Application No: BN/18/21/RES
Site Address: GTR land east of Fontwell Avenue Arundel Road Arundel BN18 0SB
Description of works: 5000 sq m of light industrial floor space (ClassB1 (b)/(c) following grant of outline planning permission WA/22/15/OUT (resubmission following BN/57/19/RES). This site is in CIL Zone 1 (Zero Rated) as other development.

OWPC39599

Walberton Parish Council wishes to object to this application.

DATE 23-12-20	DRAWING No. WM/688/P11
------------------	---------------------------

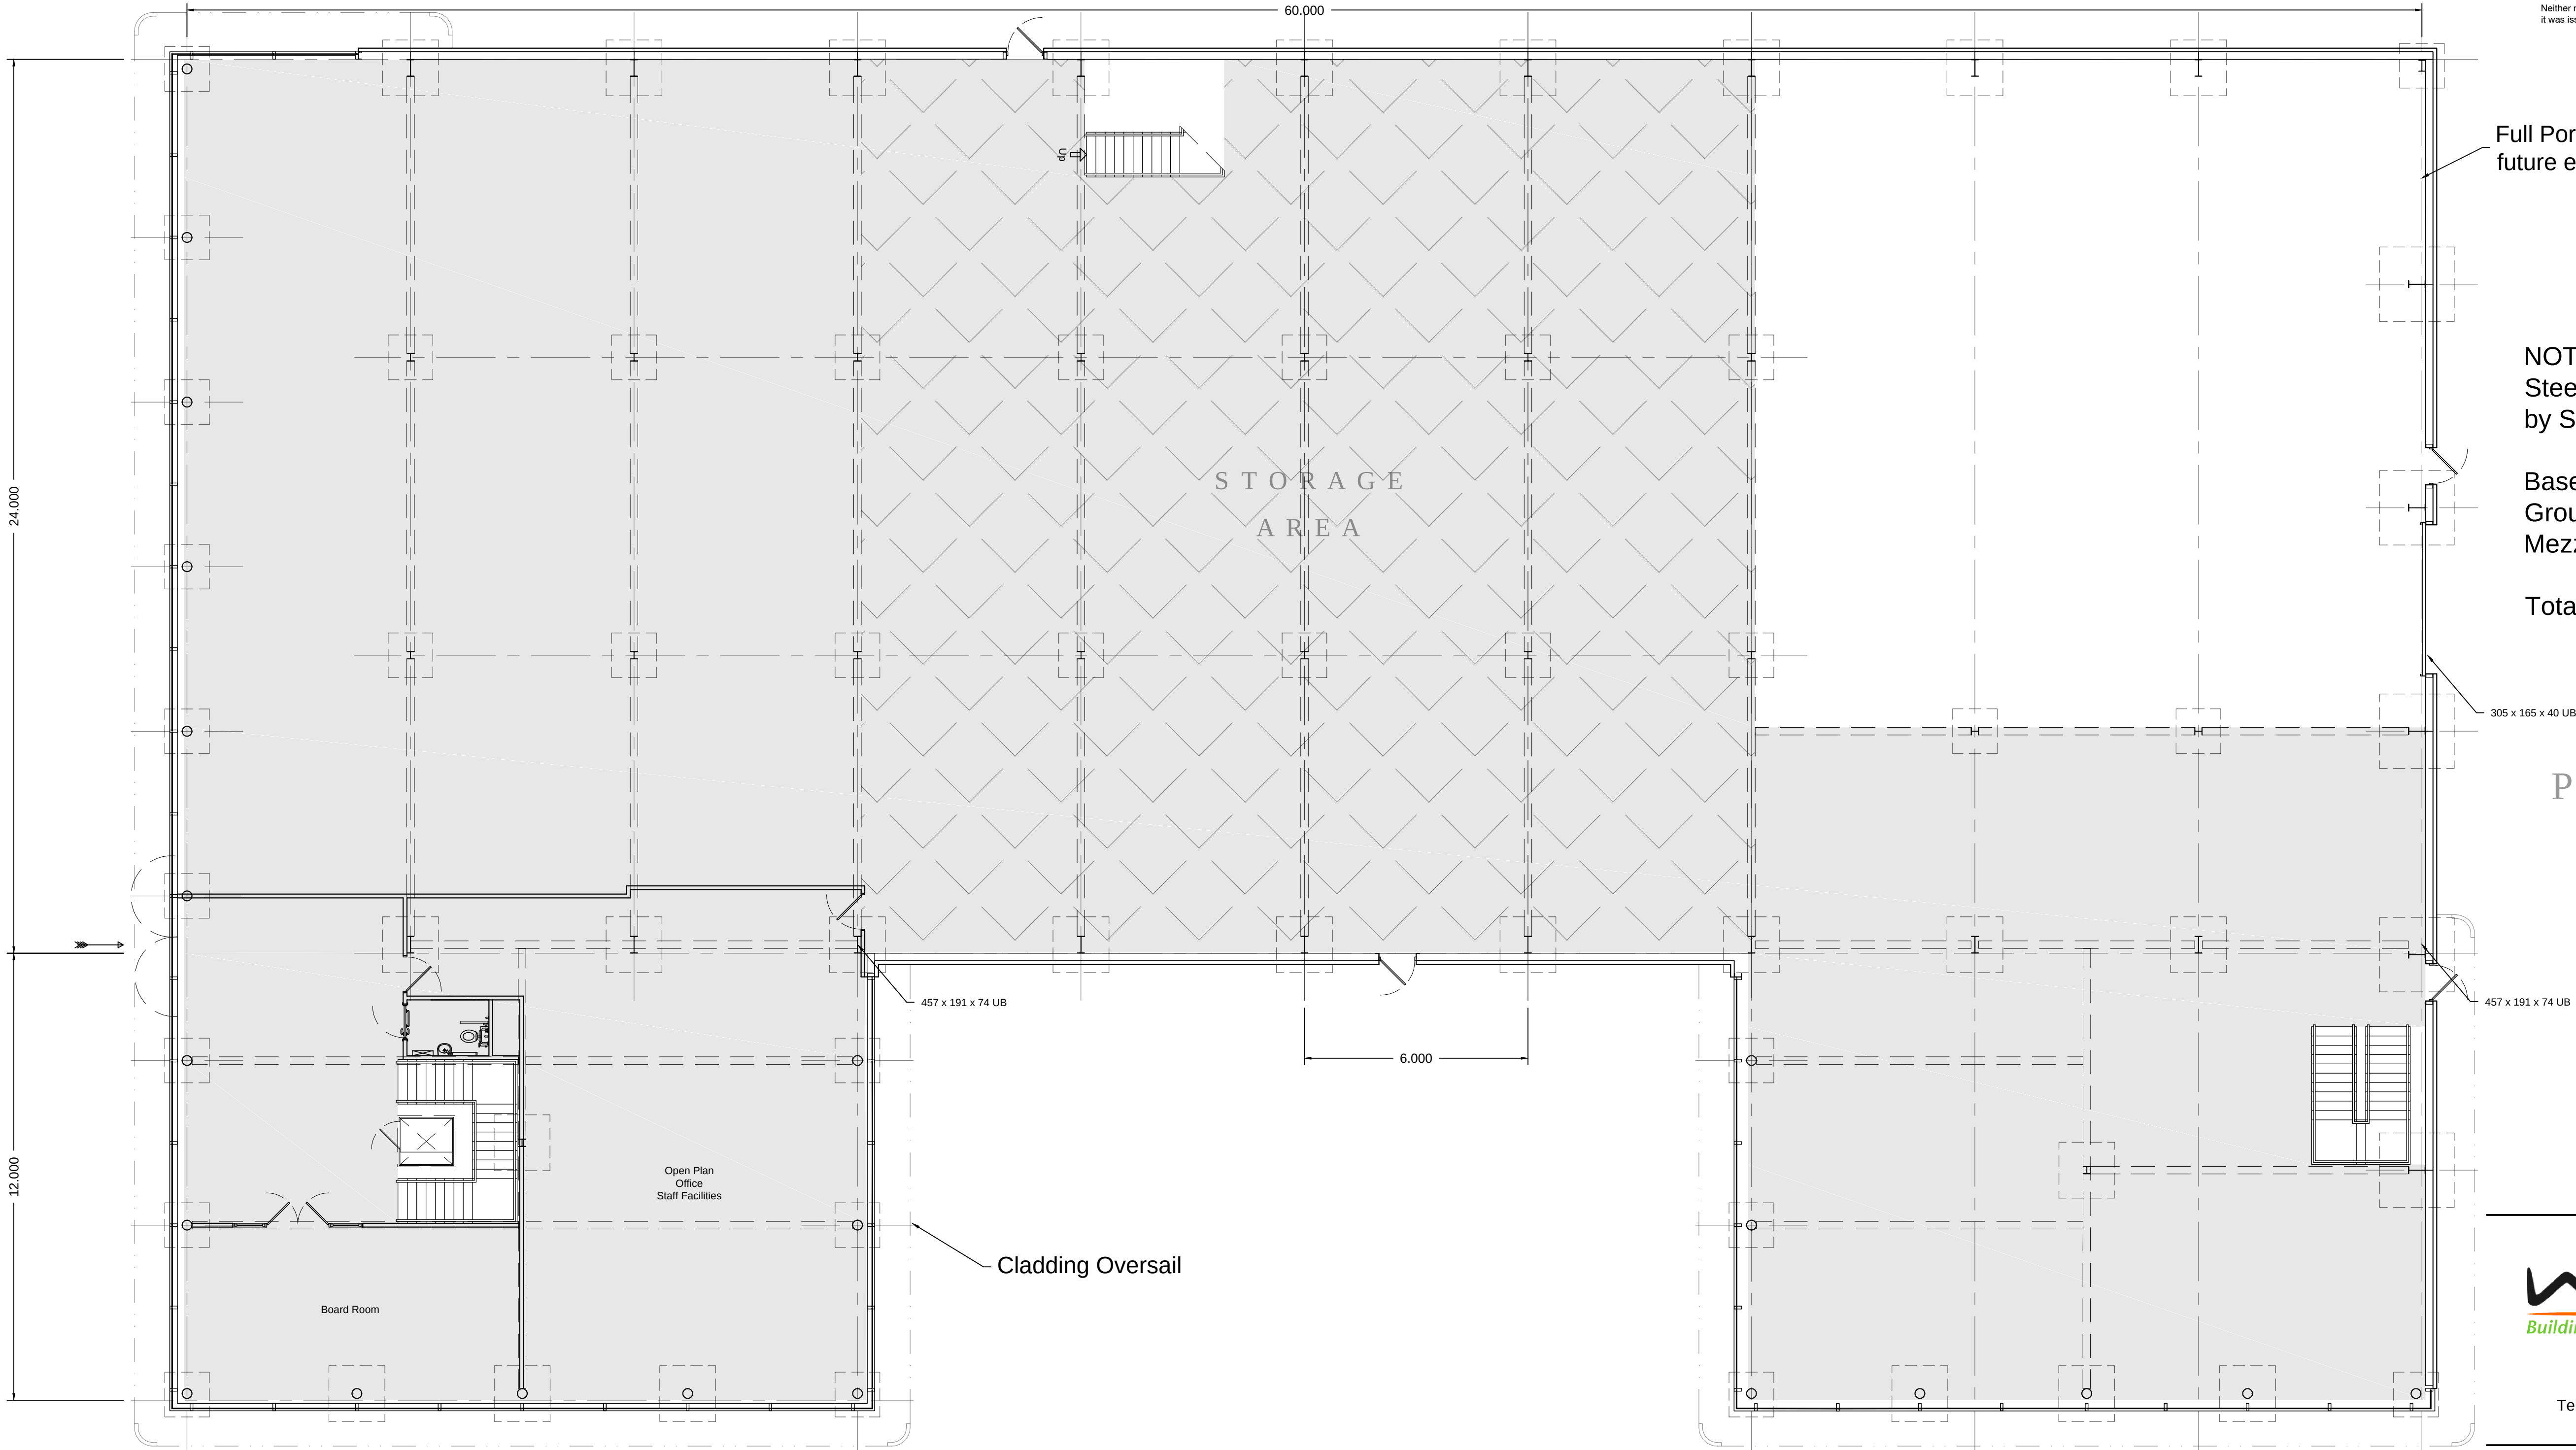
The Design Access Statement refers to, alternately, an eaves height of 8.5m (para 3) and 7.5m (para 3.6). The height shown on the plan (WM/688/P11 - there does not appear to be a plan for Block B) identifies a roof height of 9.45m with a 4 roof pitch. The distinction between the 'eaves height' which is not identified on the plans and the total height of the roof is negligible.

There is therefore a lack of clarity over the heights to be considered and conflict between the documents. In the opinion of the council the building, immediately adjacent to existing and future residential properties, despite the gentle fall of the land is too high and not in keeping with the local area.
